## **Response to Planning application from Hertfordshire County Council (T and CP GDP Order 2015)**

District ref: 6/2022/1355/MAJ  
HCC ref: WH/12730/2022  
HCC received: 23 June 2022  
Area manager: Mark Youngman  
Case officer: Samuel Tearle

FORMER BEALES HOTEL COMET WAY HATFIELD AL10 9NG

Demolition of existing building and construction of 145 residential units (Use Class C3) with private and communal amenity space, landscaping, access, associated car and cycle parking, refuse and recycling storage and supporting infrastructure.

TOTAL 124 PARKING SPACES
 AND ONE CAR CLUB SPACE
 (INCL. 15 WCH SPACES)

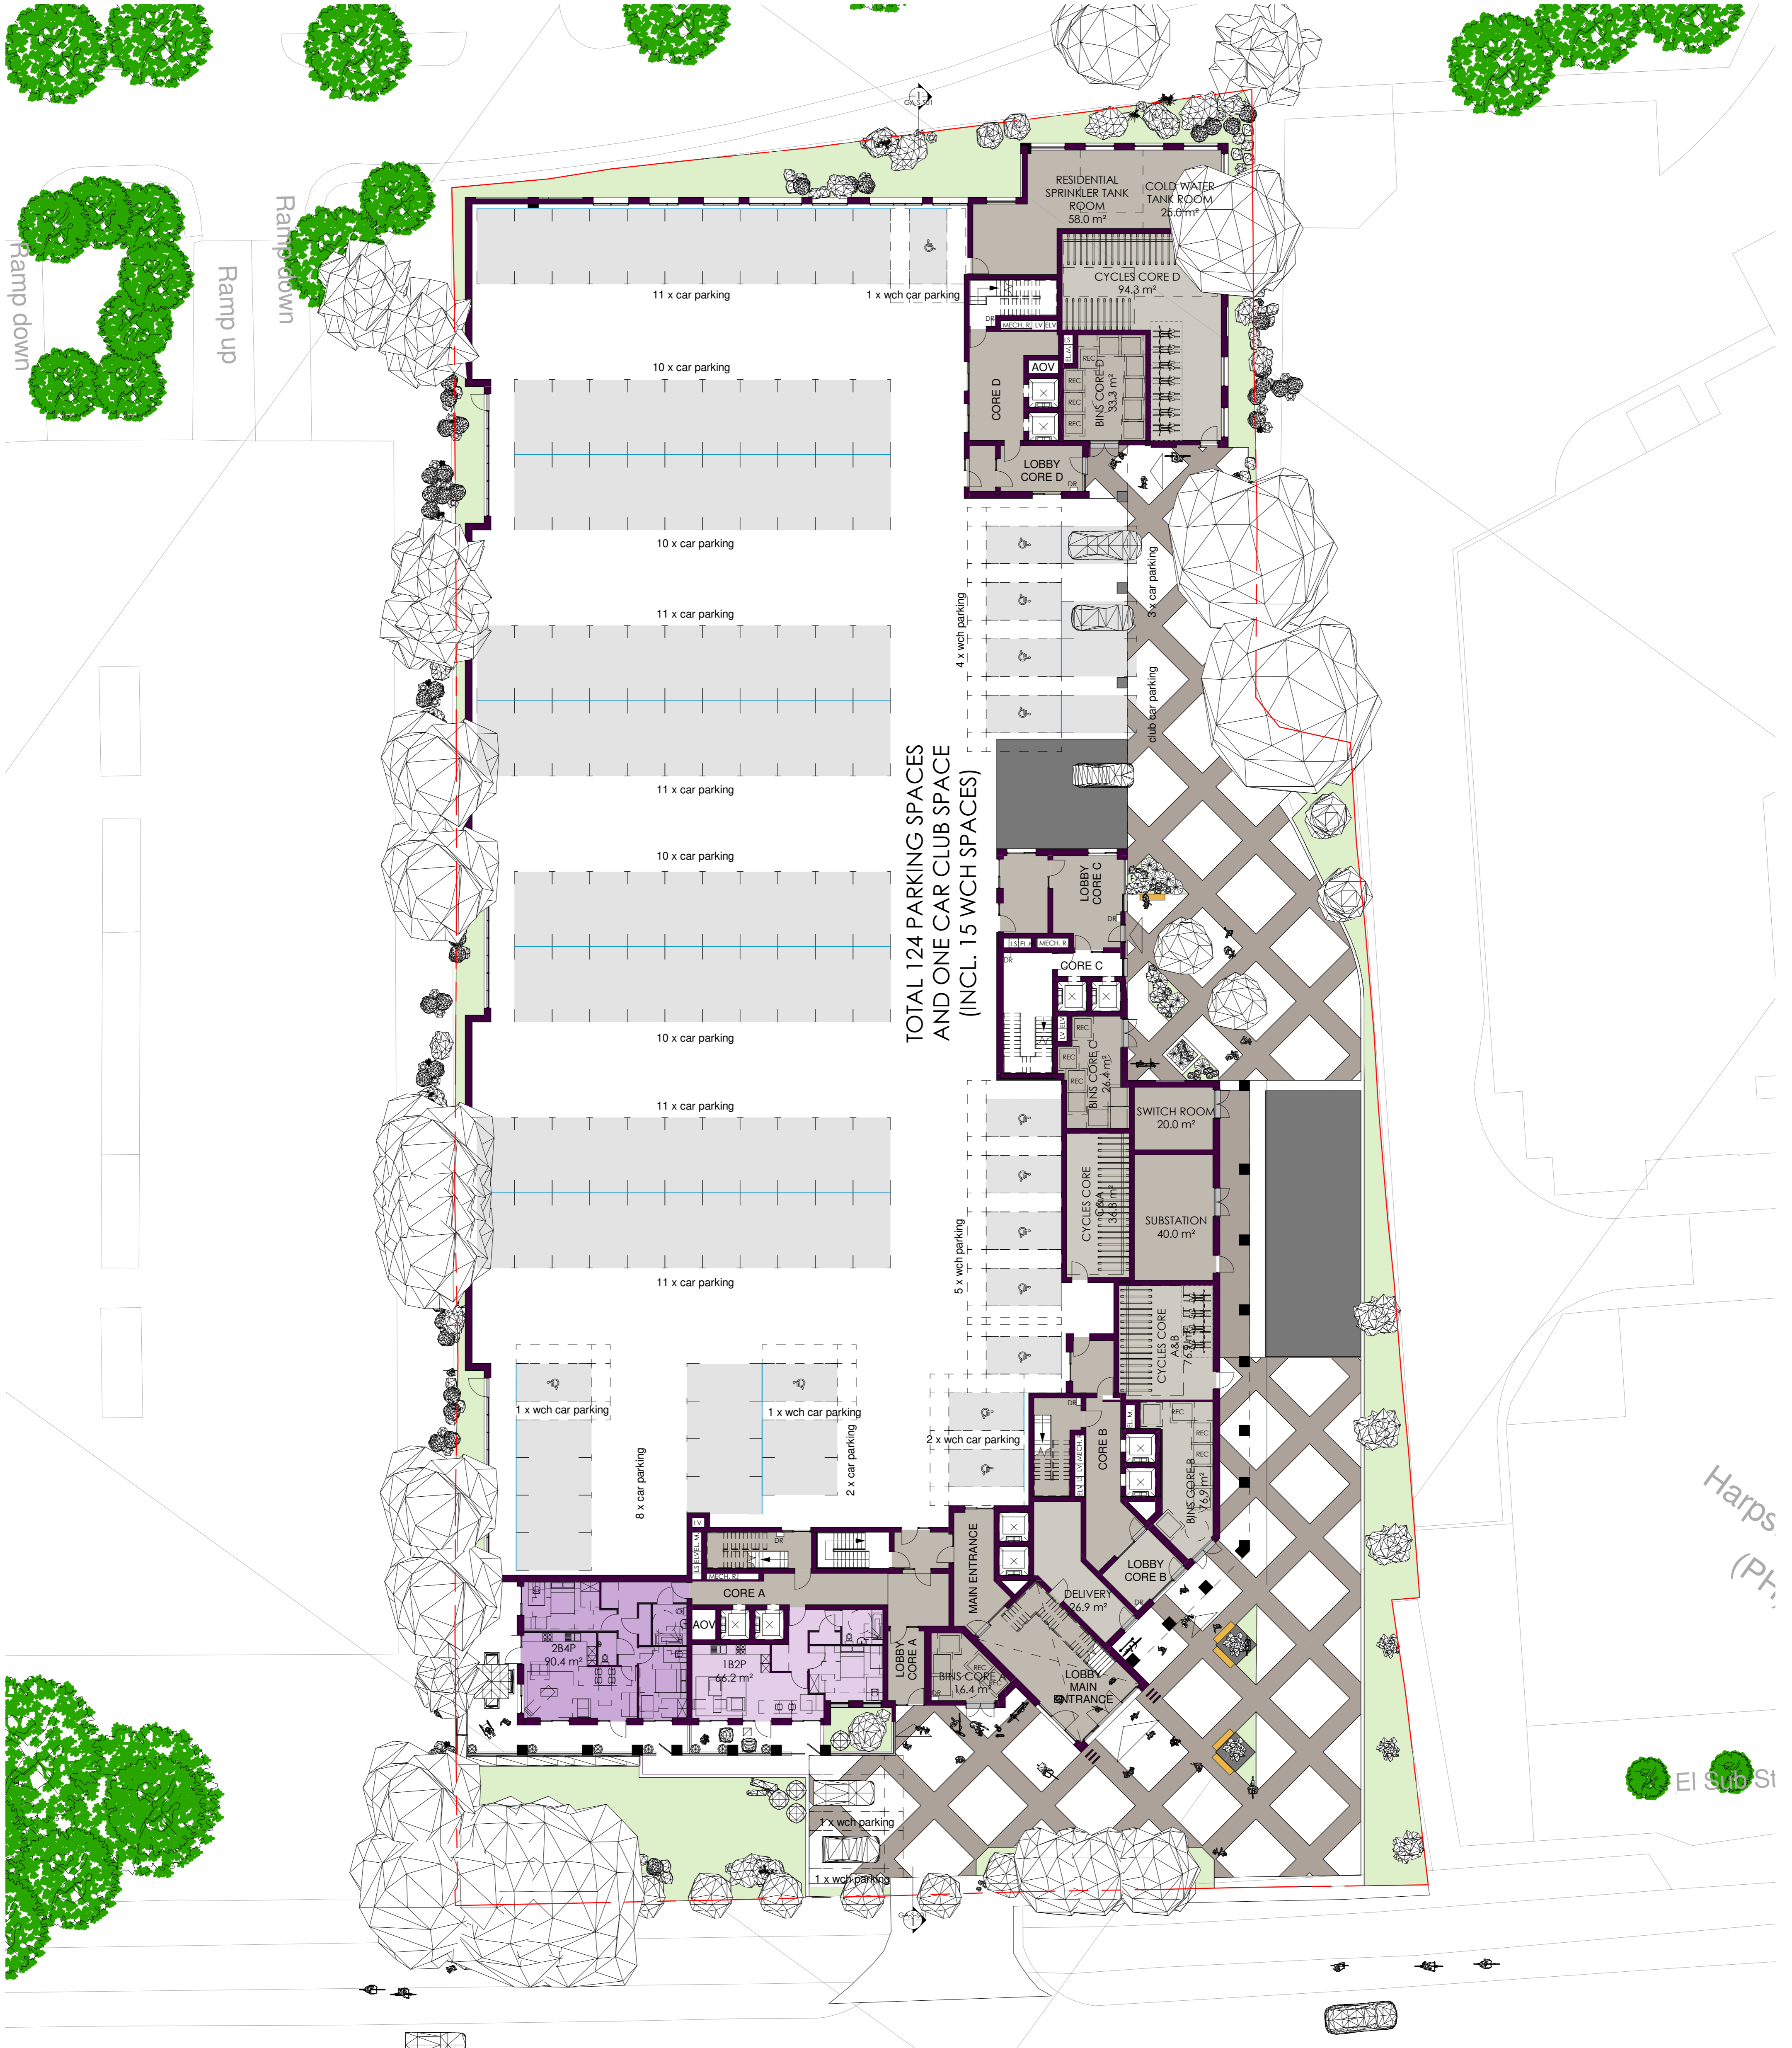
The proposals include a ground floor car park for 124 car parking spaces and one car club space (0.86 spaces per dwelling). This includes the provision of 15 disabled / blue badge spaces. The Highway Authority are satisfied with the number of spaces and allocation of blue badge spaces.

The Transport Statement states the proposals will provide 13 electrical vehicle charging spaces. This is unsuitable and against building regulations (Infrastructure for charging electric vehicles: Approved Document S - GOV.UK ([www.gov.uk](http://www.gov.uk))). This notes that all new Residential Buildings with parking in a covered car park must have a charging point for each dwelling.

The Highway Authority therefore recommend by way of planning condition that each parking space is fitted with an active EV charging unit.
